Our ref: DOC20/569521  
Senders ref: SSD-10352

**Subject: EES comments on Response to Submissions for Moriah College Redevelopment – Queens Park campus – SSD-10352**

**Subject: EES comments on the Response to Submissions for Moriah College redevelopment – Queens Park campus – SSD-10352**

A summary of possible plant species for further development at detailed design of each stage is provided as a guide and point of commencement for the final planting selection and arrangement.

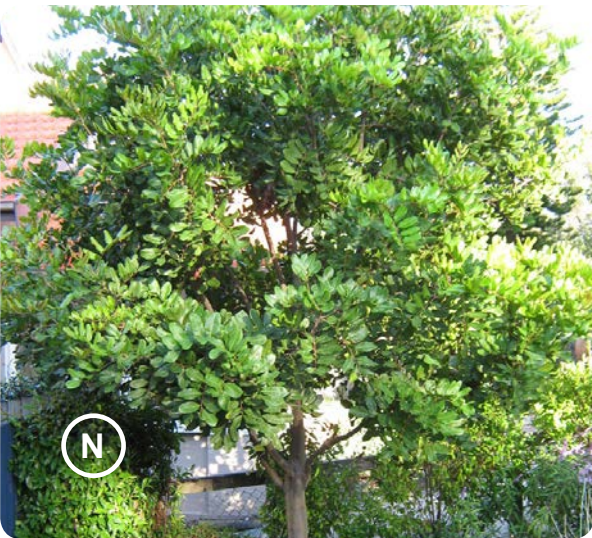
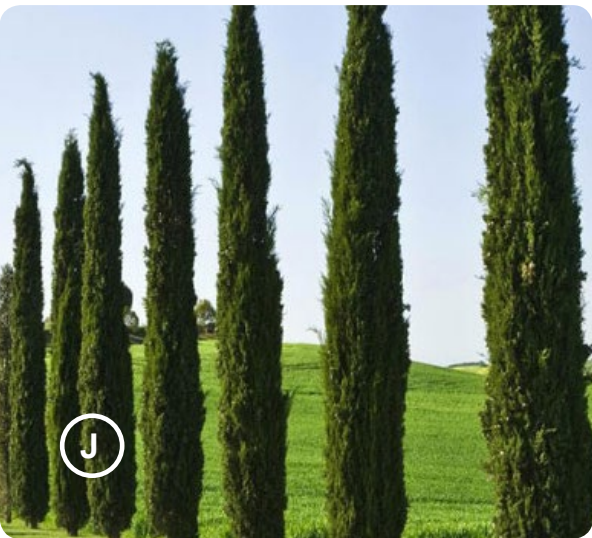
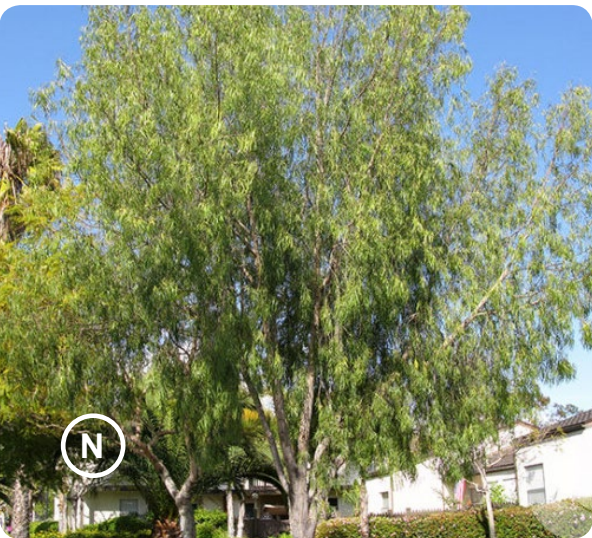
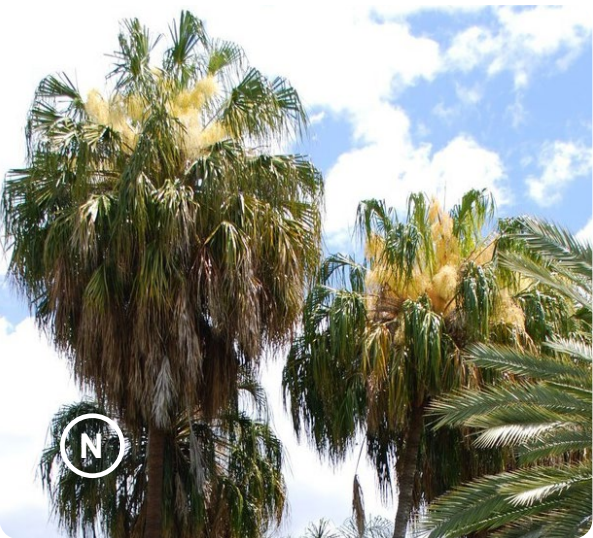
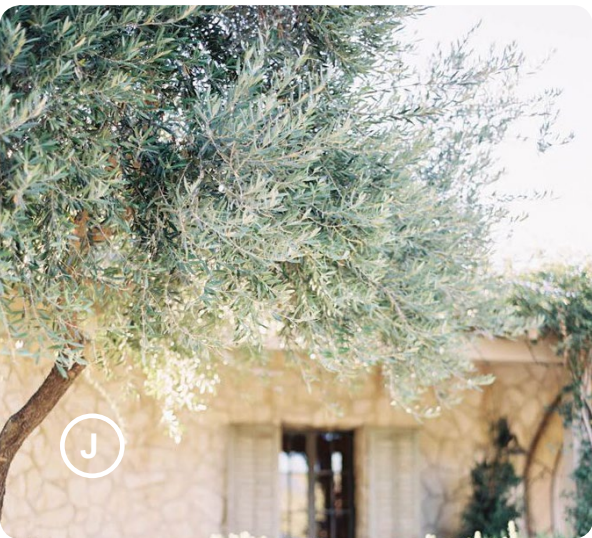
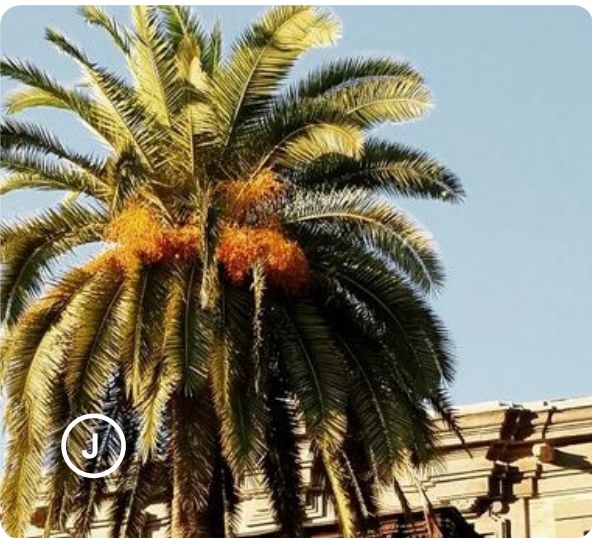
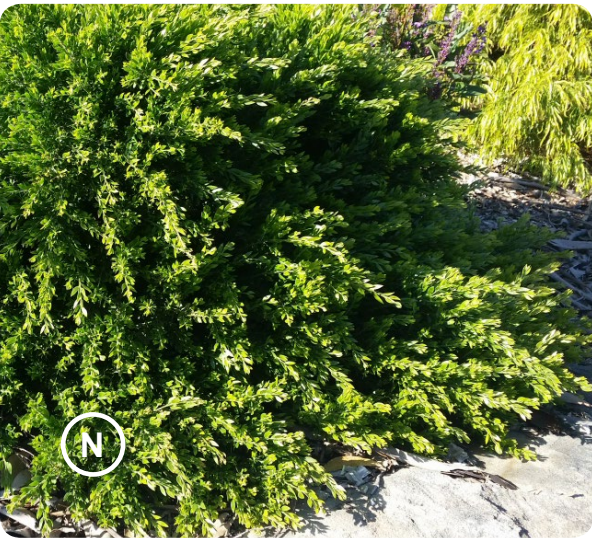
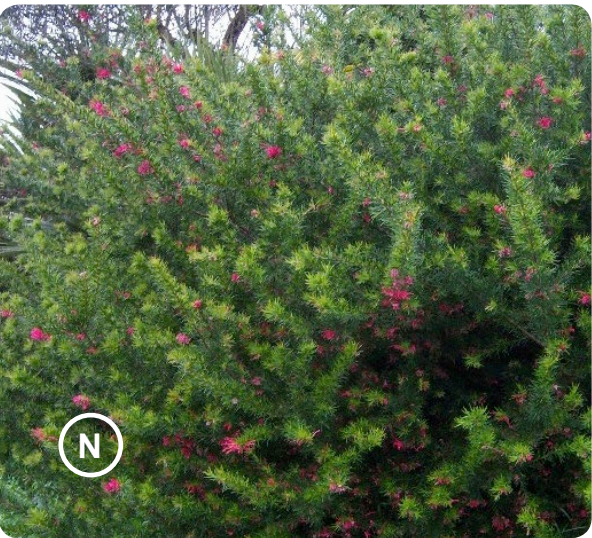
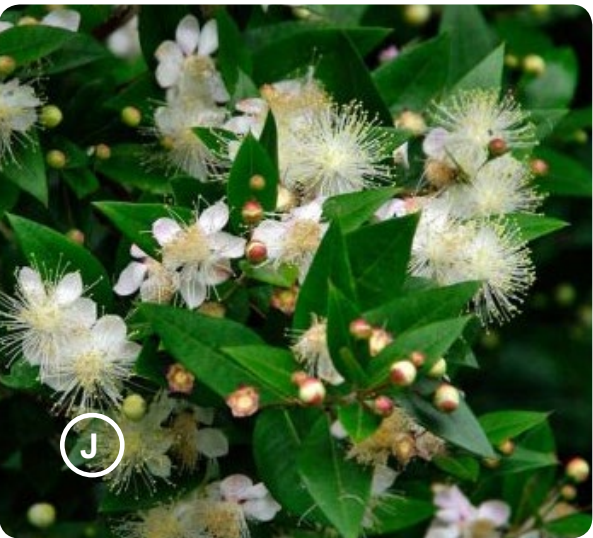
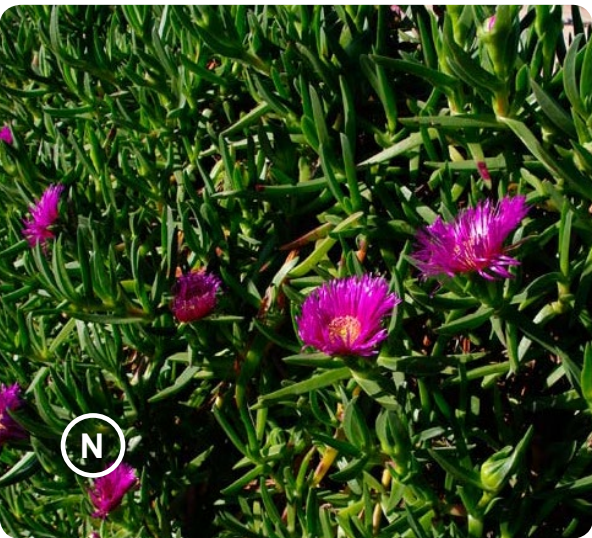
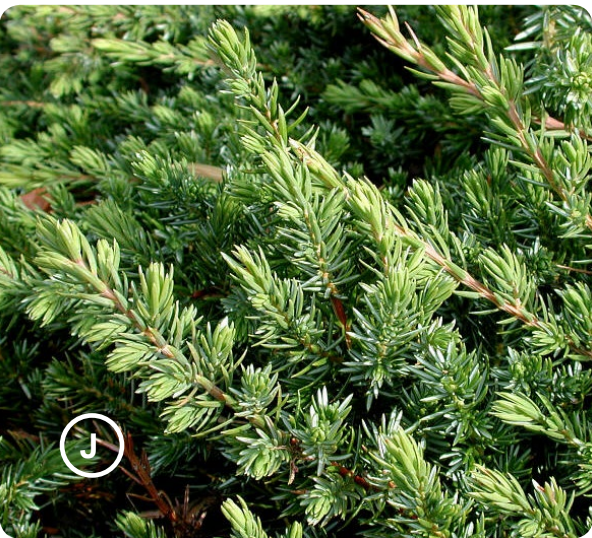
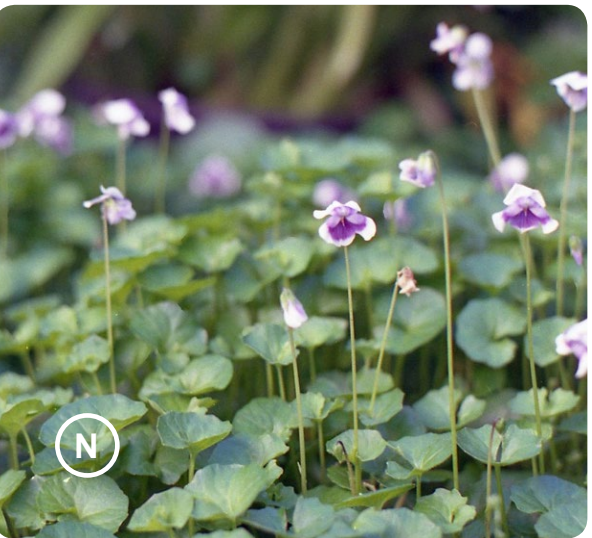
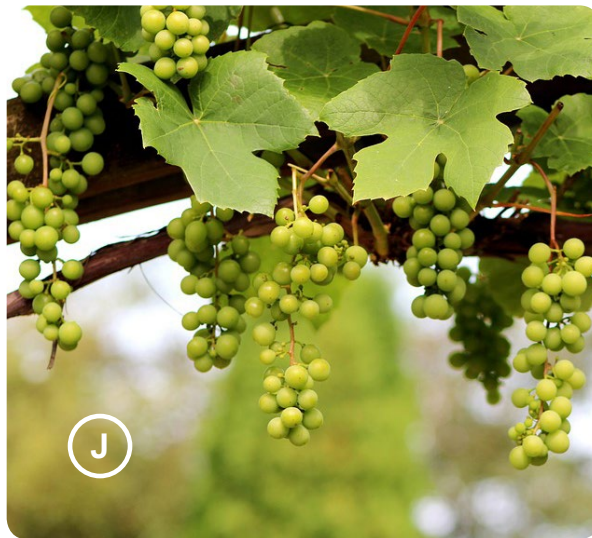
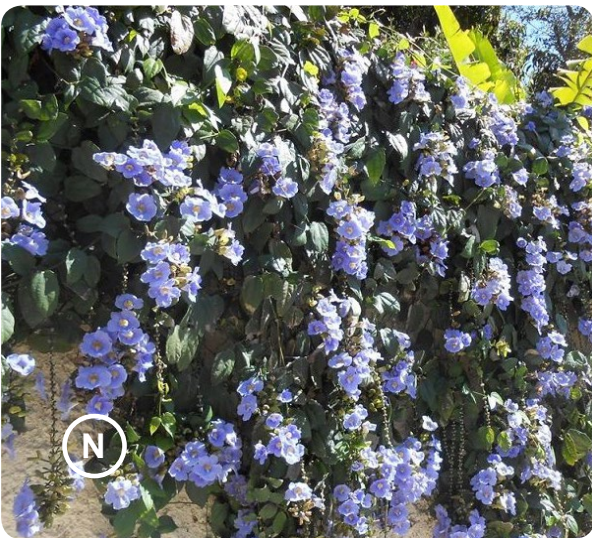
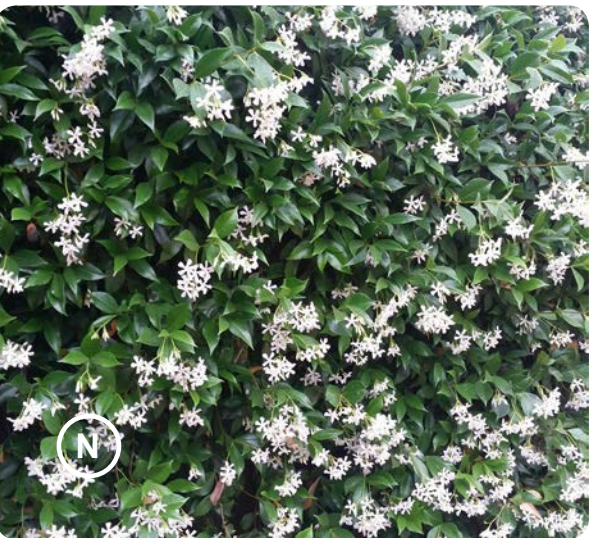
- the RTS states “The species selection is represented by a majority of ESBS native trees. There remains a selection of exotic and broader native species to ensure the cross-cultural narrative of the school is clearly illustrated” (section 2.3.5, page 11). It is unclear why “broader native species” are proposed to be planted rather than ESBS provenance species

As previously advised, the planting of exotic and non-locally occurring native plants in the past has impacted ESBS at the site. Except for the proposed garden plantings (which includes a cultural garden/ science garden/ edible produce garden/learning gardens and performance garden - see Landscape drawings -24), EES recommends local provenance ESBS species are only used in the site landscaping.

The proponent needs to clarify if the ESBS species listed in the amended Landscape Drawings (see Stage 2 Tree Species Masterplan and amended Plant Schedule) were recommended by Cumberland Ecology. The species listed in the Landscape Drawings are not included in Cumberland Ecology’s VMP ESBS plant list (see Table 6, Appendix C in the VMP). It is not clear if these additional species occur naturally in remnant ESBS in the local area. Reconciliation is required between the species listed in the landscape drawings, the VMP and species from the local remanent ESBS.

The RTS indicates locally endemic tree species are proposed to dominate the interface with the adjoining banksia reserve (Lot 23) and landscape treatment fronting Baronga Avenue and Queens Park, and their presence continues throughout the campus to strengthen the ecological network, interspersed with culturally significant species and regional natives. It also notes that all previously listed invasive species ( including *Lampratinthus spectabilis* and *Thunbergia grandiflora*) have been removed from the planting schedule (page 12)

- ***The site landscaping (except for the learning landscape gardens) -including areas adjacent to the VMP Area shall use a diversity of local native species from the ESBS.***
- ***Enough area/space is provided on site to allow the trees to grow to maturity.***
- ***Tree planting at the site shall use advanced and established local native provenance trees with a minimum plant container pot size of 100 litres, or greater for local native tree species which are commercially available. Other local native tree species which are not commercially available may be sourced as juvenile sized trees or pre-grown from provenance seed***
